**Addendum No. 1**

RE: Contract # C204368

**Richmond County (R-3421A, R-3421B)**

I-73/74 FROM US-74 BYPASS WEST OF ROCKINGHAM AT SR-1109  
(ZION CHURCH RD) TO NORTH OF SR-1304 (HARRINGTON RD).

PROJECT REFERENCE NO.	SHEET NO.
R-3421A	UC-19
DESIGNED BY: JKC	
DRAWN BY: JKC	
CHECKED BY: RBW	
APPROVED BY: RBW	
REVISED:	
NORTH CAROLINA DEPARTMENT OF TRANSPORTATION	
UTILITIES ENGINEERING SEC. PHONE: (919) 707-6690 FAX: (919) 250-4151	
UTILITY CONSTRUCTION PLANS ONLY

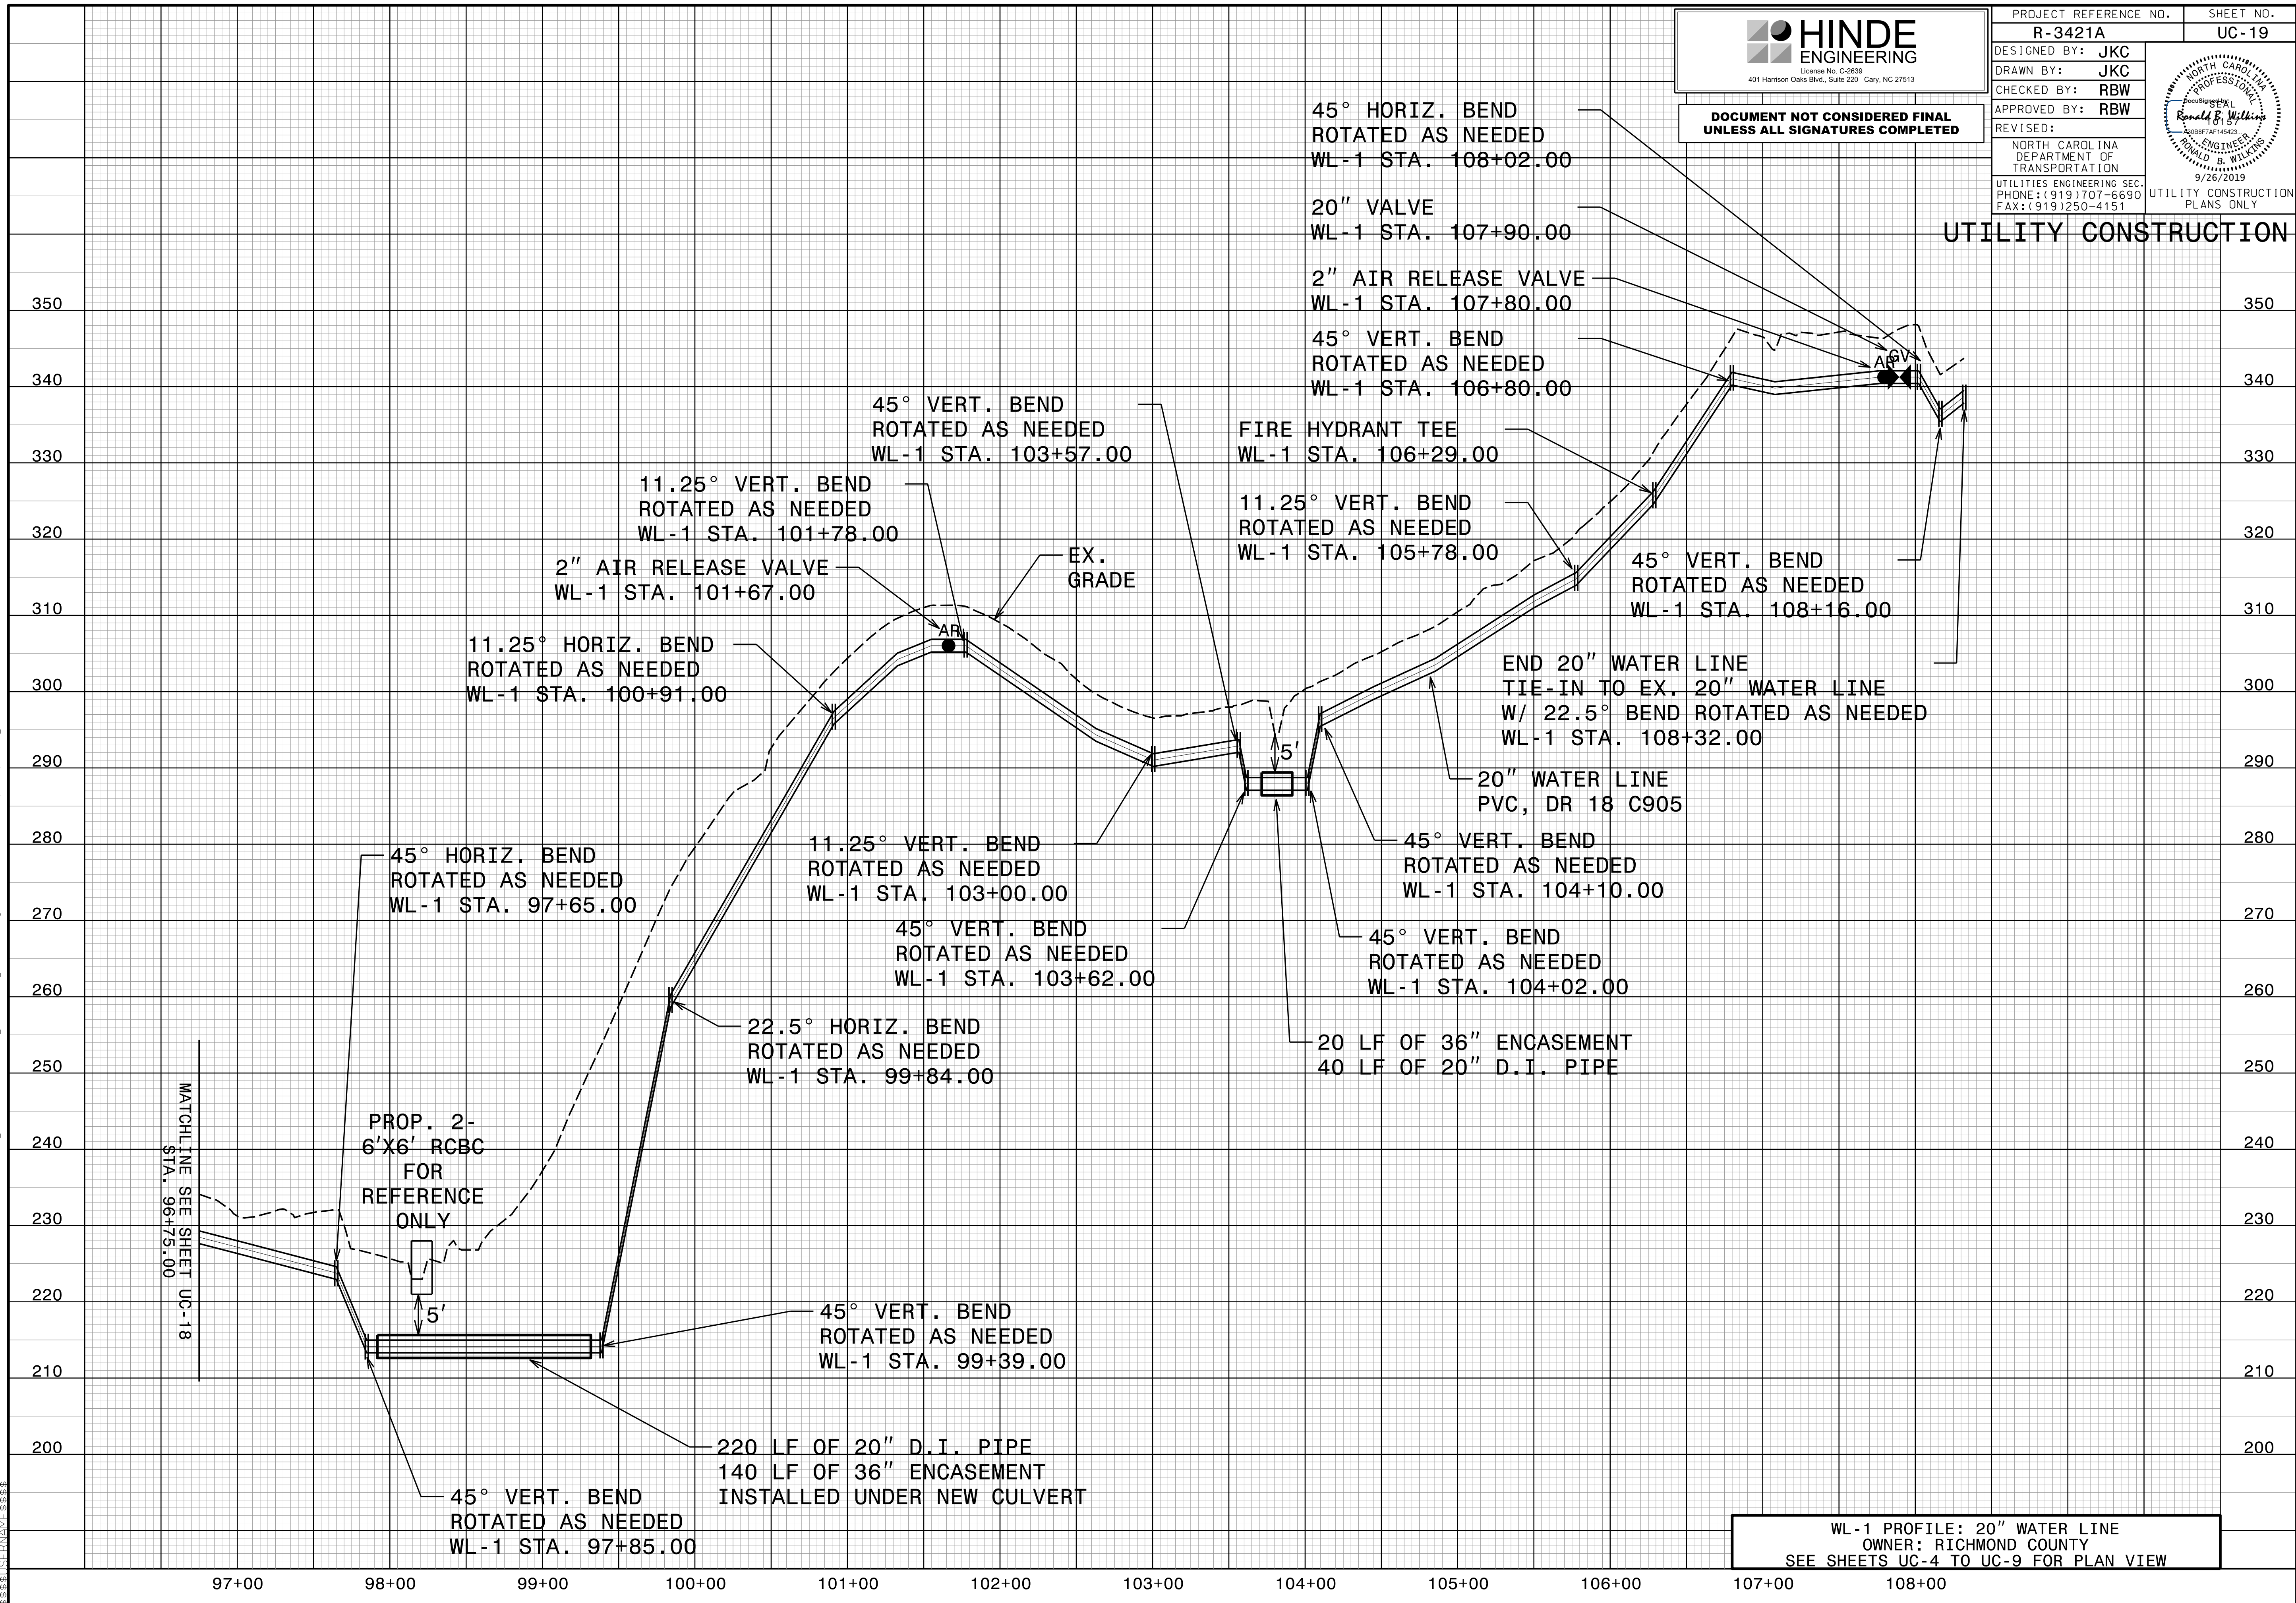
Sheet No.	Revision
UC-3A	Revised to add detail
UC-7	Revised to add note for 36" Encasement
UC-19	Revised to add note for 36" Encasement
New Sheets R-3421A UO-1 thru R-3421B UO-21	Added Utilities by Others plans
